Application Reference: TRA10036

### **Intention to submit requests for changes**

WORK NO.59 ACCOMODATION TRACK
FOR BLACKWELL FARM

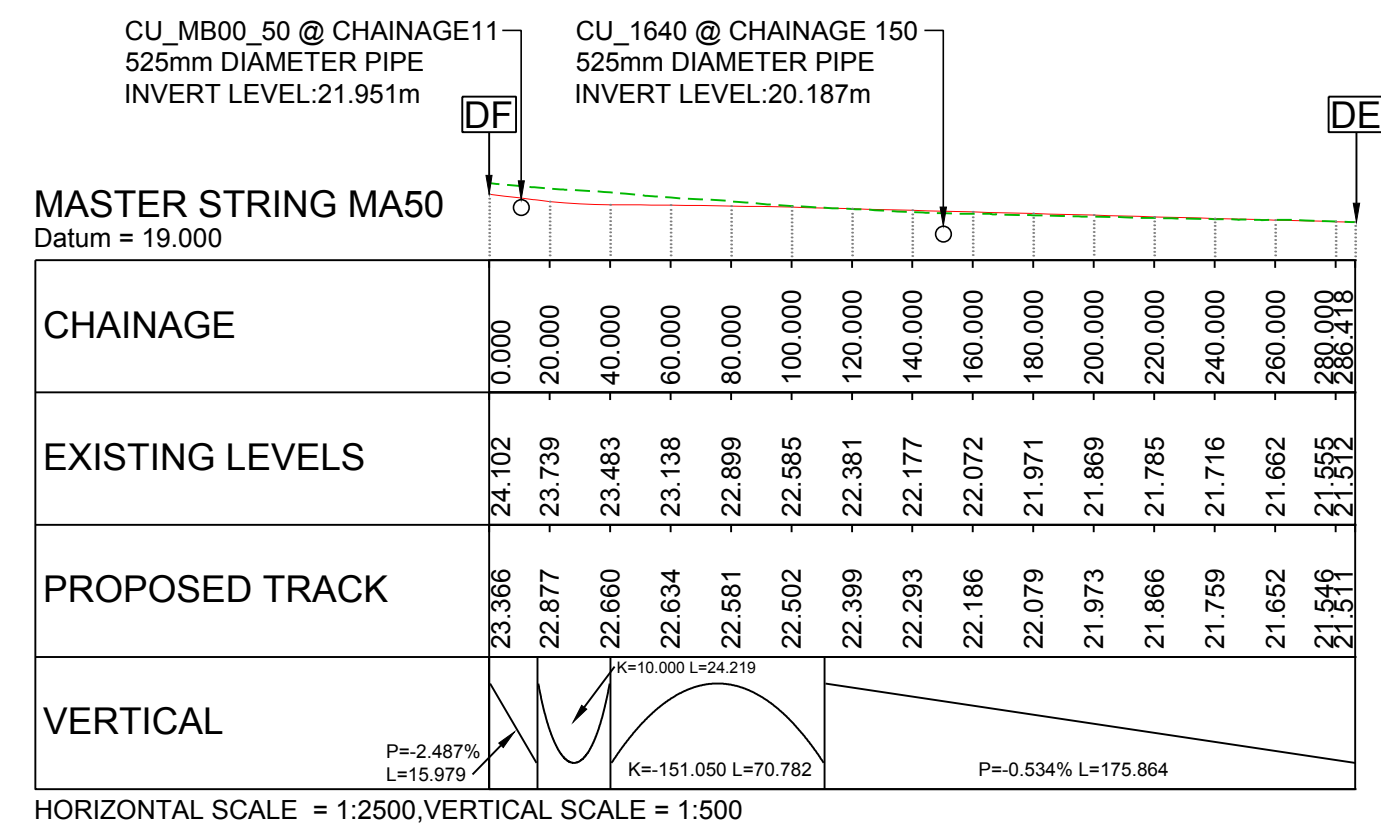
### **Change 2 – associated development - accommodation work – provision of access to Blackwell Farm (Work 59)**

The access track proposal was added to the application in response to pre-application consultation and discussion with the landowner of Blackwell Farm as their preferred route for this accommodation work. An objection to that access has been received from an adjacent landowner concerned that the junction with the public highway would be very close to their property. Highways England has continued to work on options for access to Blackwell Farm and has identified another way of providing access by widening the corner and junction of the existing public highway rather than constructing an entirely new access track on what is currently greenfield land in agricultural use. The land required for widening is mostly highway verge, with an area in the ownership of the party for whom the access works are required and a small area is in third party ownership. The proposed widening would require less land take and less new hard surfacing than the current track and would move the junction of the access away from the objector's property. The local highway authority have been informally consulted on the proposed change and have raised no objection. Environmental assessment to prepare supplementary environmental information for that area is ongoing.
